7th March 2018

I am writing in objection to application A/8/18/PL for the land behind 1 – 6 The Cottrells.

Ground Floor Plan @ 1:100

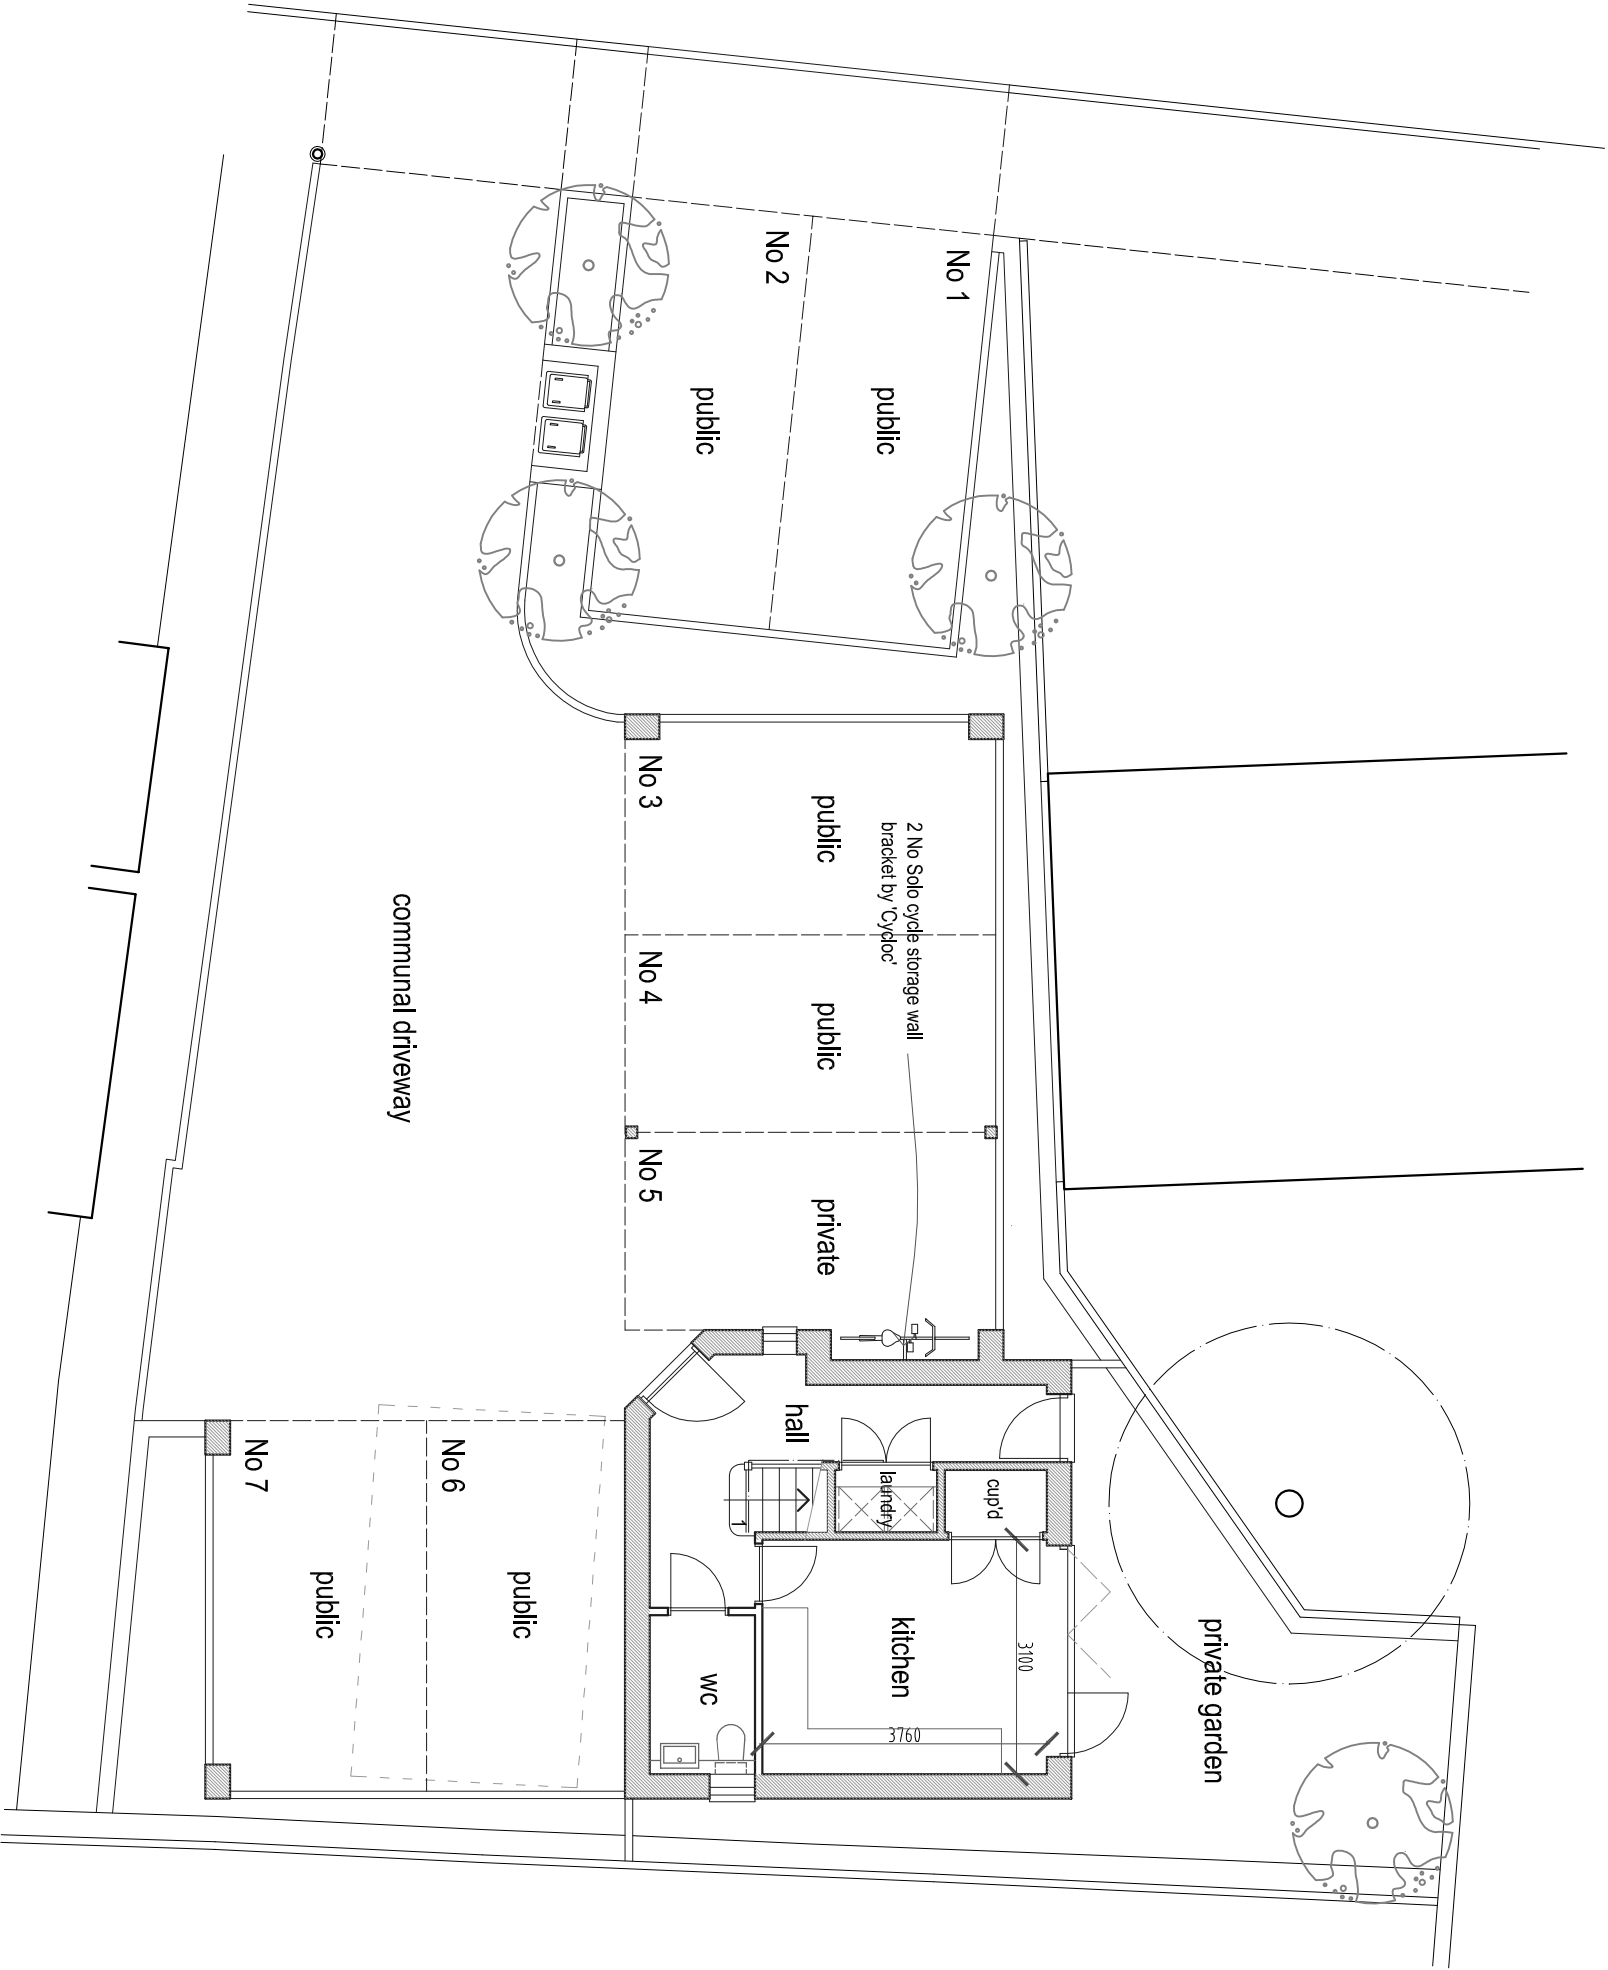
The original approved plans are for a 2 bedroom property, with revisions for a 3 bedroom turned down. The addition of a hallway downstairs, and the knowledge that all of the services have been put in place upstairs to move the kitchen after the building has been signed off, leads me to believe the developers are planning on reinstating the third bedroom that was dismissed. A three bedroom home would undoubtedly need more than the one parking space allocated to the property and cause even more parking issues down and already congested road. I would request that the internal layout be subject to planning controls to prevent this happening at a later date.

Another point to consider is that the plans now show brick posts in the car port as opposed to the timber posts in the approved plans. Which is it to be? Perhaps the conservation officer should take some interest and ensure that the posts used are the ones that best fit the area and not whatever the developer decides is easiest and cheapest?

Roof Plan @ 1:100

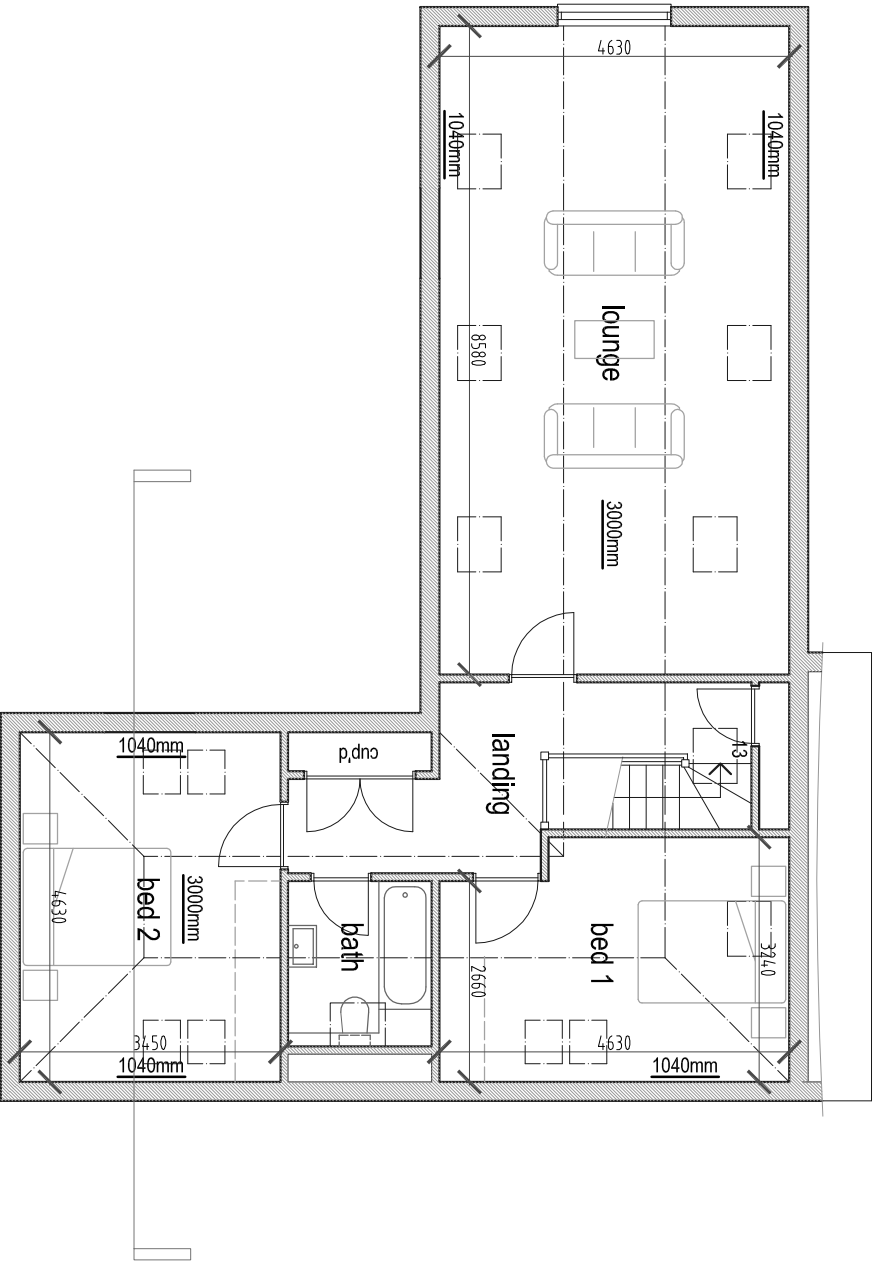
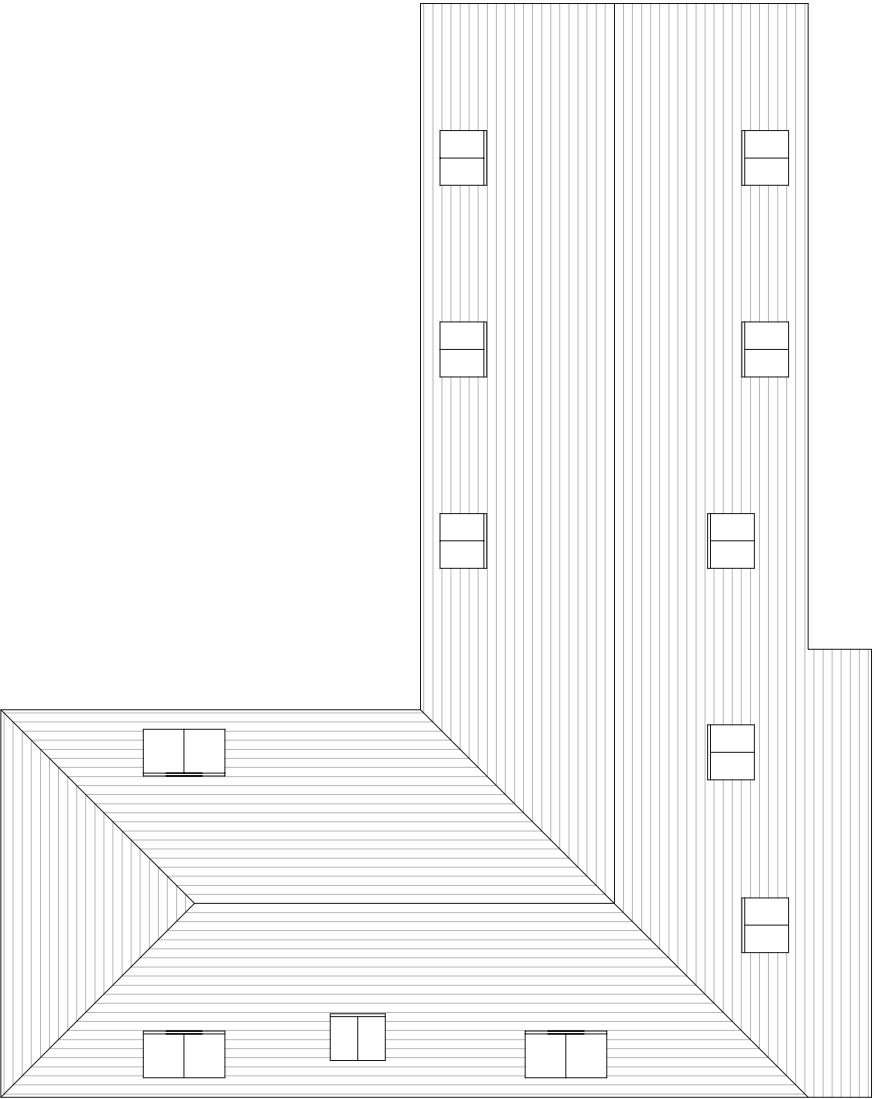
The developer has built a building with a completely different roof elevation and pitch to those approved. The approved plans show a hip end on the roof facing the rear of 5 The Cottrells, however a barn end is what has been built. This gives an overbearing presence to the property, blocks light to the surrounding gardens and doesn't fit in with the local houses. This barn end has been installed with the aim of increasing the internal space available and benefits The Cottrells or the conservation area in no way. The pitch of the roof is much higher and steeper than the original plans, again to the benefit of the developers and the detriment of the road, resulting in a much larger and more imposing building than the homes surrounding. I would also like to add that the new plans of the elevation show two different types of roof facing 5 The Cottrells. The front (west) elevation shows a hip end; the side (south) elevation shows a barn end. What exactly are they planning on doing with this?

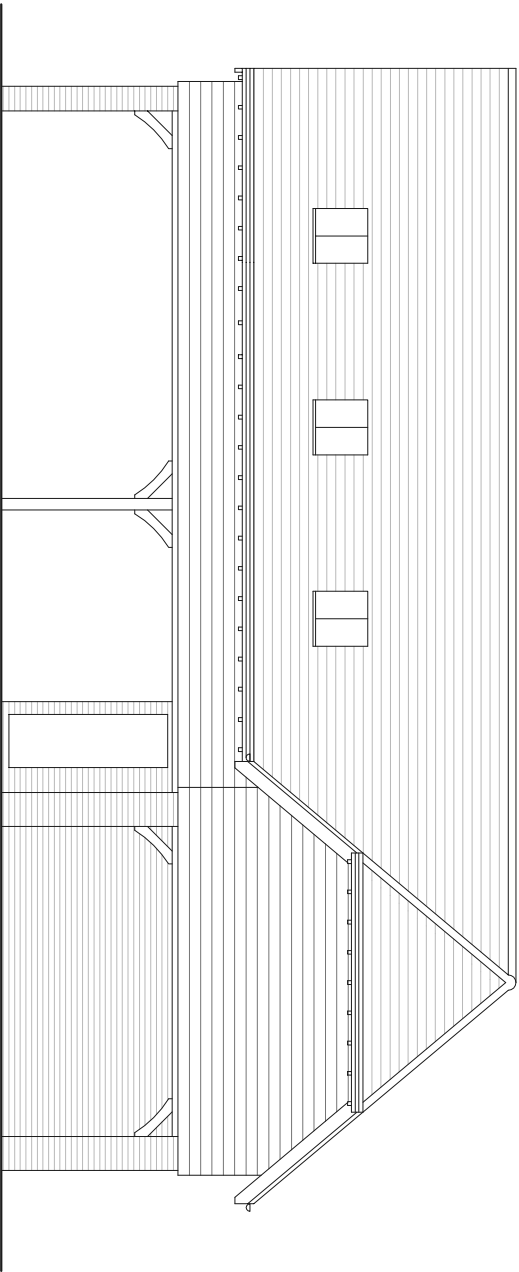
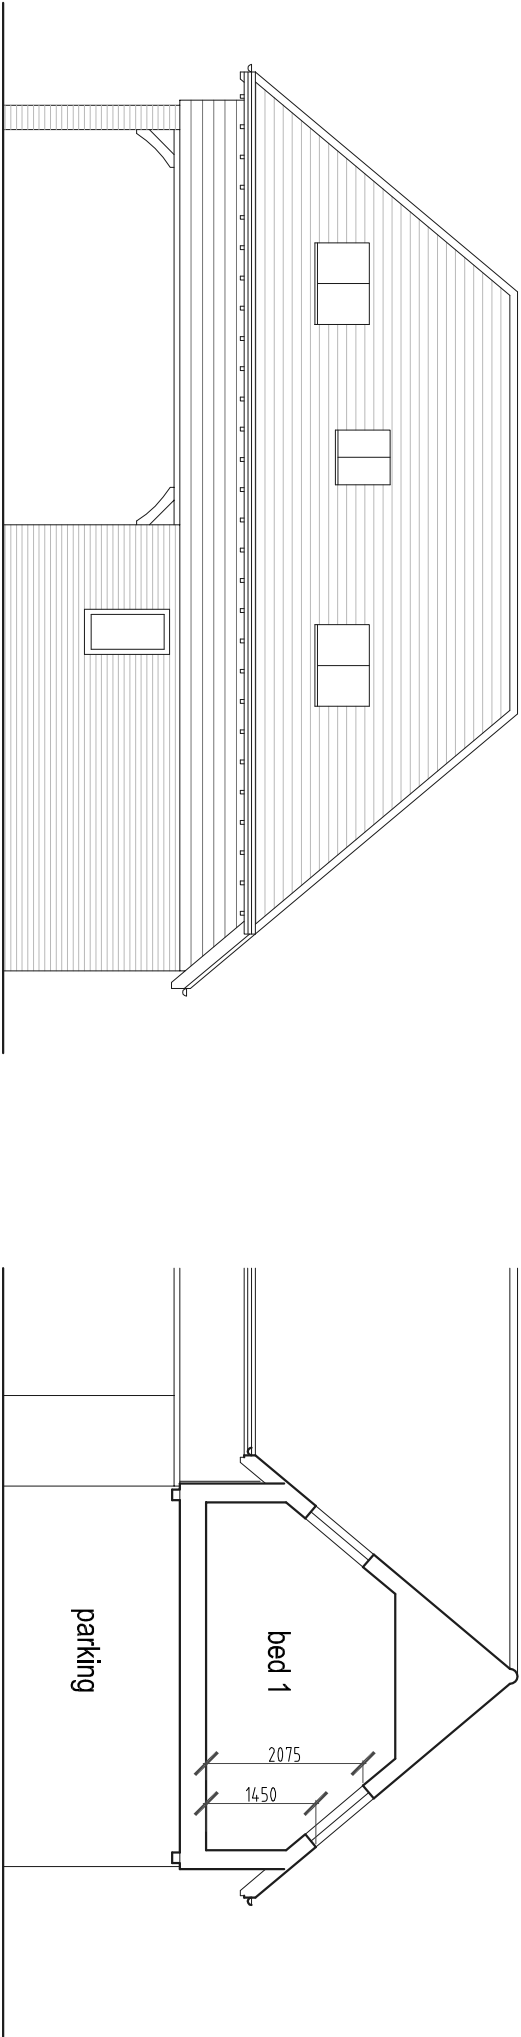
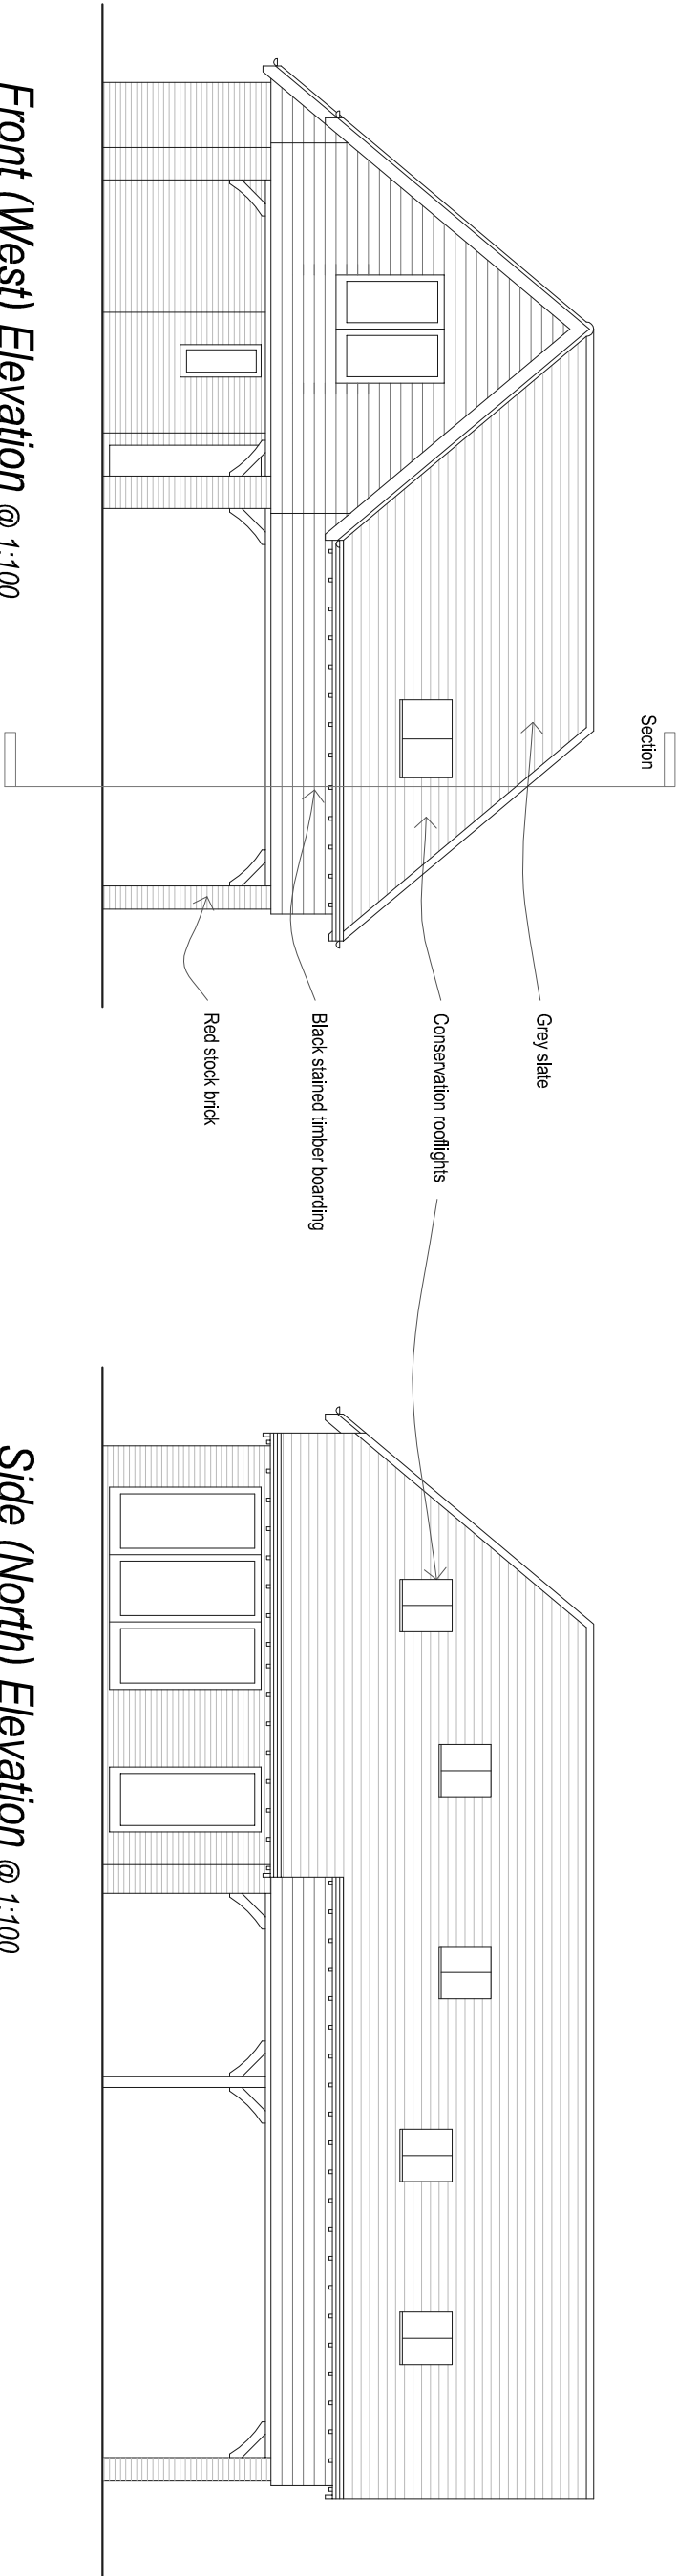
The rooflights that have been put in place are at a different height and of a different type to the ones shown in the approved plans. The windows that have been installed appear to be ordinary Velux and not the escape heritage rooflights that were passed in planning. The lowered heights of the windows mean they look straight into the rear bedrooms of 1 – 6 The Cottrells and greatly affects our privacy. We now keep the blinds shut permanently to prevent our privacy being invaded and do not look forward to being able to watch our future neighbour as they sit in their living room. This objection is as much for the future resident's privacy as ours. Has the development been

granted special permission to put the rooflights at a lower height or is this another modification the developer has seen fit to put in?
